STATE OF NORTH CAROLINA  
DEPARTMENT OF TRANSPORTATION

April 13, 2006

Subject: **Additional Information for Section 401 Water Quality Certification/Neuse Buffer Certification and Section 404 Nationwide Permits 14 & 33** for US 1/64 From US 64/SR 1009 (Tryon Road) Interchange to South of I-40 in Cary, Wake County; **TIP No. U-3101C & D**; State Project No. 8.1403101; Federal Aid Project No. STPNHF-1(4); USACE Action ID Nos. 200120922 & 200421562; NCDENR-DWQ Project No. 041055; WBS Element 34897.1.1.

SHEET 9 OF 19
 6-11-04

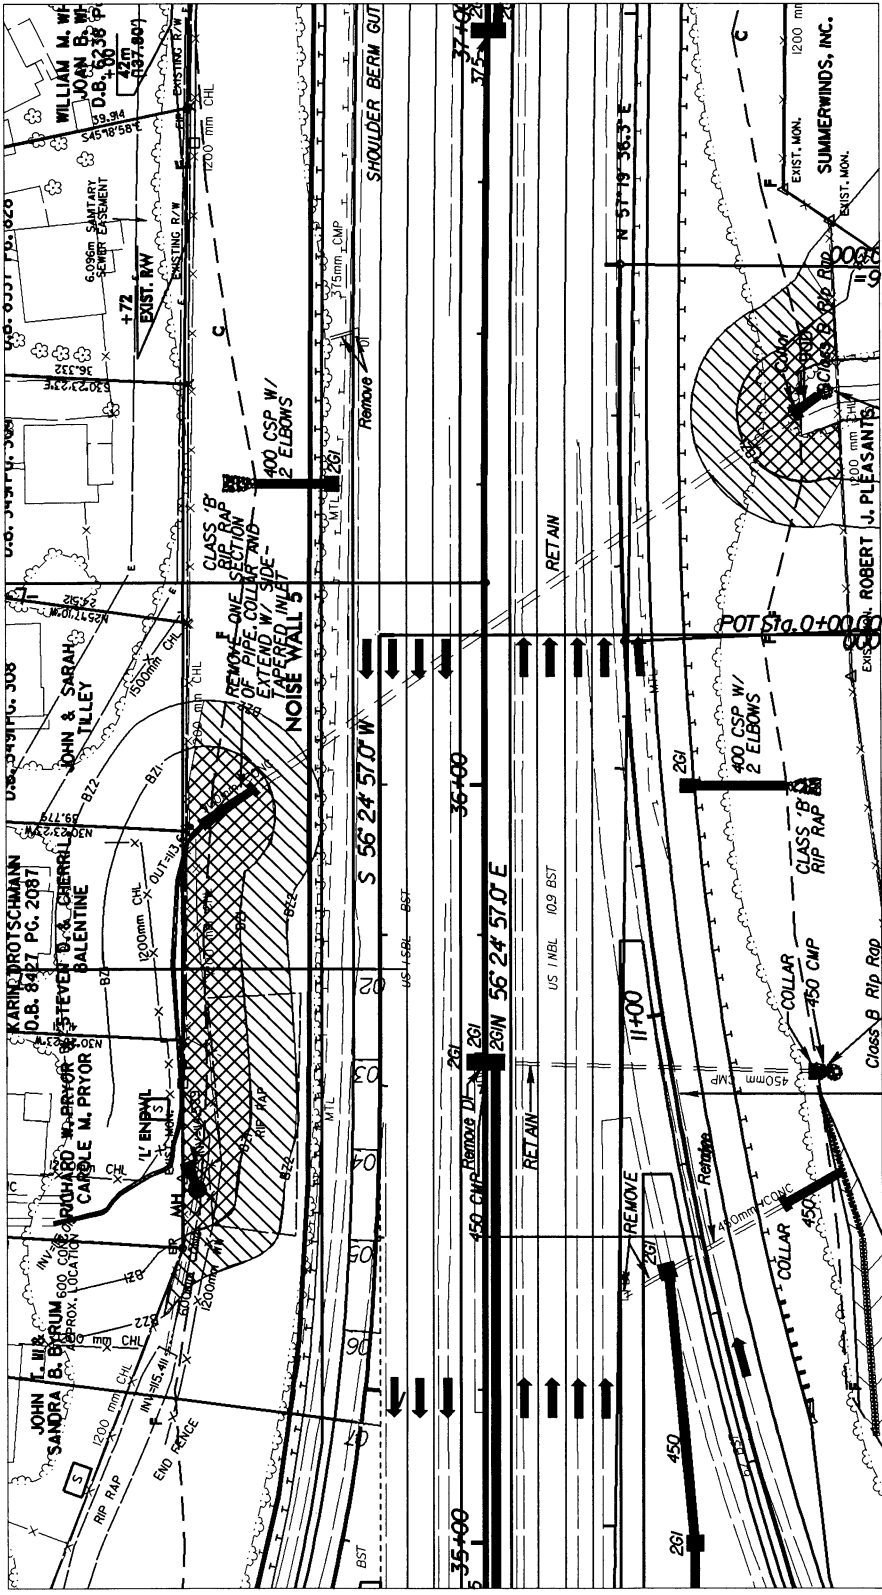
Additionally, the NCDOT will be incorporating a design change to address concerns that the “water quality pipes (WQP)” that outlet the stormwater sometimes have a tendency to “push” the water over the level spreader ahead of the outlet, instead of totally filling the level spreaders as intended. NCDOT will be shortening the WQP where it enters the level spreader at two locations, left of Station 27+80-L-LT and left of Station 43+60-L-LT, rather than having the pipe end directly ahead of the level spreader as currently permitted. A flared riprap-lined ditch will also be incorporated from the end of the pipe to the level spreader as a method to allow some energy dissipation prior to the flow entering the level spreader. The following sheets are attached: level spreader calculation sheet, revised Buffer Sheet 9 of 19 (Site 2), revised Buffer Sheet 12 of 19 (Site 5), and Plan Sheets 8, 2-JJJ, 2-TT, and 2-UU.

NCDOT would like to reserve the right to make adjustments to reduce the outlet velocities from the WQPs into the level spreaders at other locations, as described above (as depicted on revised buffer Sheet 9 of 19) or by similar means. All methods of adjustment will occur outside of the riparian buffers and no additional impacts will be incurred.

PROJECT REFERENCE NO. U-3101		SHEET NO. 8	
R/W SHEET NO.			
ROADWAY DESIGN ENGINEER		HYDRAULICS ENGINEER	
PRELIMINARY PLANS <small>DO NOT USE FOR CONSTRUCTION</small>			
CONST. REV.		R/W REV.

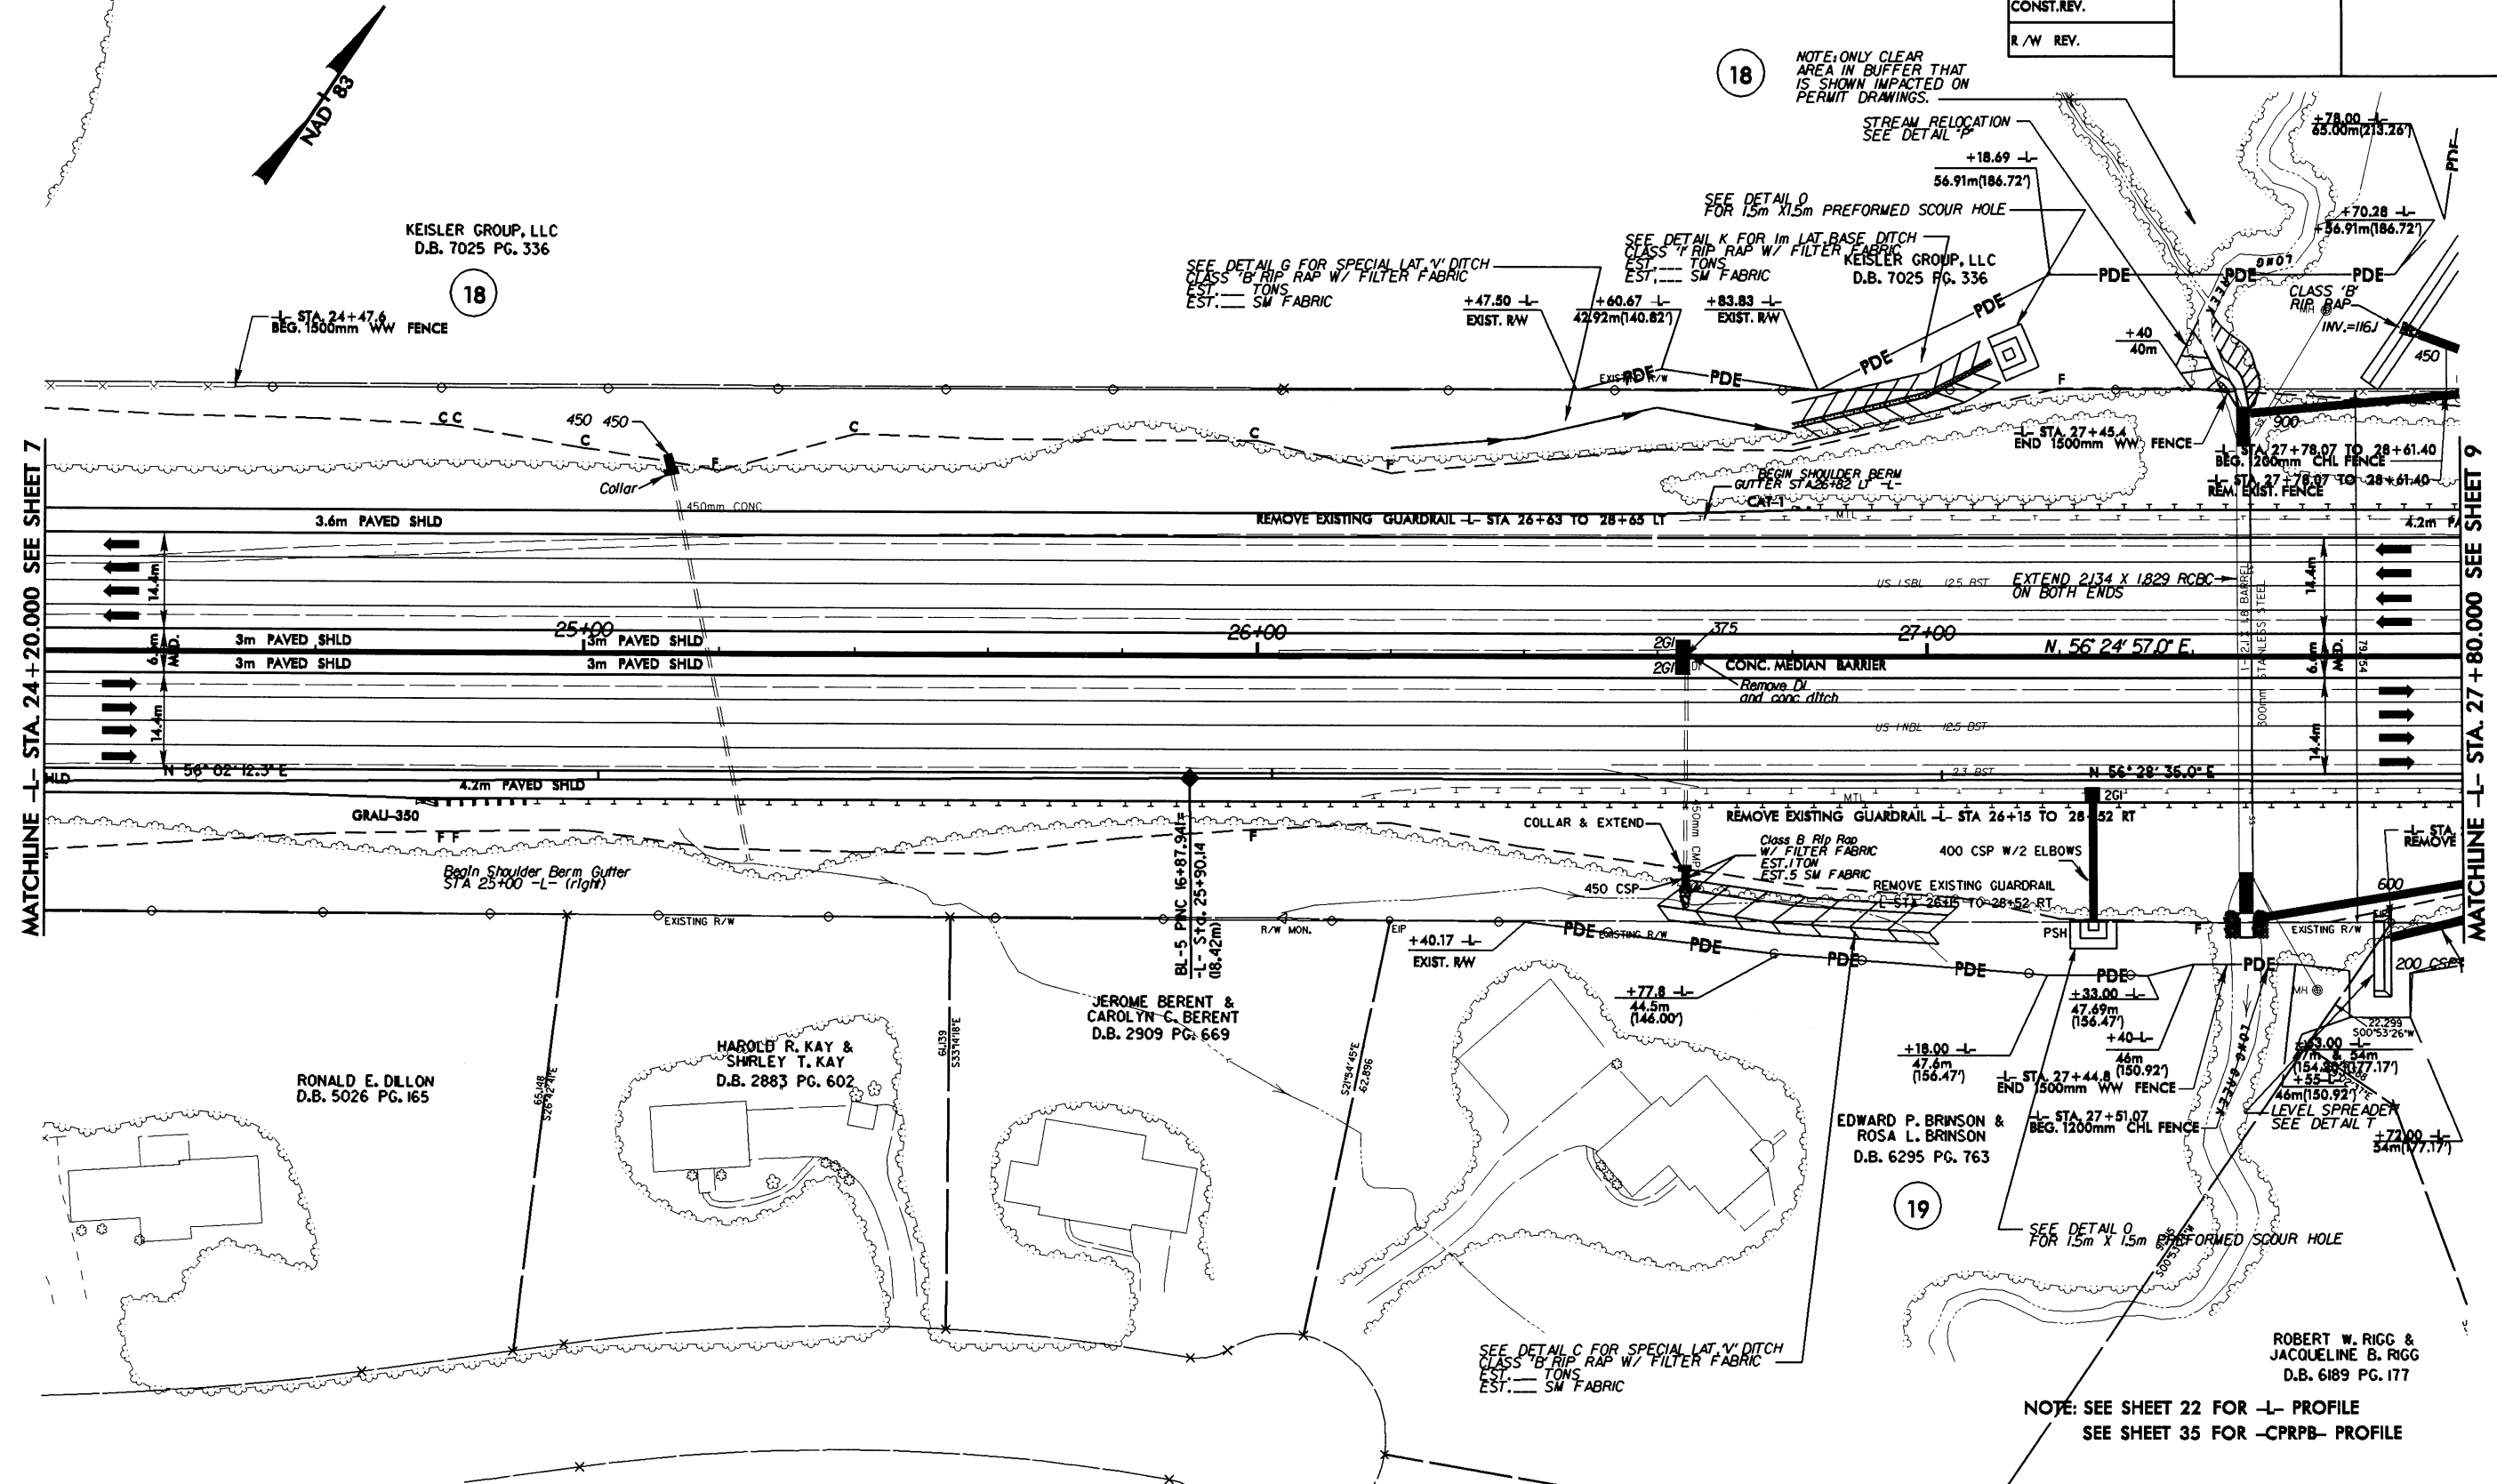
The purpose of this letter is to provide the NC Division of Water Quality (DWQ) and the US Army Corp of Engineers (USACE) with additional information for the 401 water quality/buffer certification and the 404 permit to address design changes. Due to the failure of the existing metal cross pipe at Station 26+60-L-RT, the pipe will be abandoned in favor of a new outlet to the left of Station 26+60. To satisfy the buffer requirements, a level spreader with splitter box will be incorporated. The preformed scour hole (PSH) previously permitted will act as a forebay for the level spreader, and a berm will be constructed on the R/W side of the level spreader to ensure water from the PSH does not bypass the level spreader. The roadway fill slope will provide confinement on the other side of the level spreader and the level spreader will also include endwalls. A new section of pipe with splitter box will be constructed to convey the initial inch of water from the base ditch to the PSH, and to convey the overflow storm capacity to the RCBC located at Station 27+50-L-LT. The resulting increase in drainage area will be negligible (487 acres vs. 489 acres, a 0.4% increase), and the water quality impact to Long Creek will be negligible.
